Rezoning Transportation Analysis

Petition Number: 2019-168

General Location Identifier: 03325102, 03325104, 03325118, 03325103

Date	Description
12-18-2019	First Review
01-14-2020	Second Review (FO)
02-18-2020	Third (WB)
05-15-2020	Fourth Review

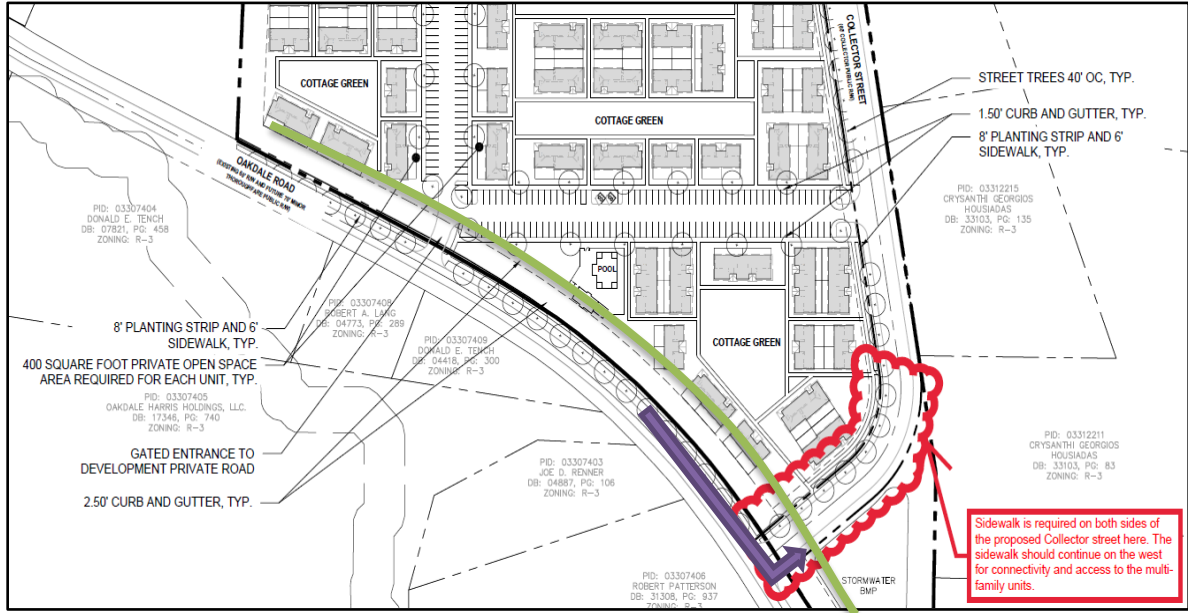
7. ~~To comply with the council adopted Charlotte Walks and BIKE Policy, CDOT is requesting the petitioner construct a 12-foot multi-use path along the Oakdale road. See multi-use path shown above in green.~~

8. ~~Per NCDOT, the petitioner should revise the site plan and conditional note(s) to include an eastbound left turn lane from Oakdale onto the proposed Collector street. See left turn lane shown above in purple.~~
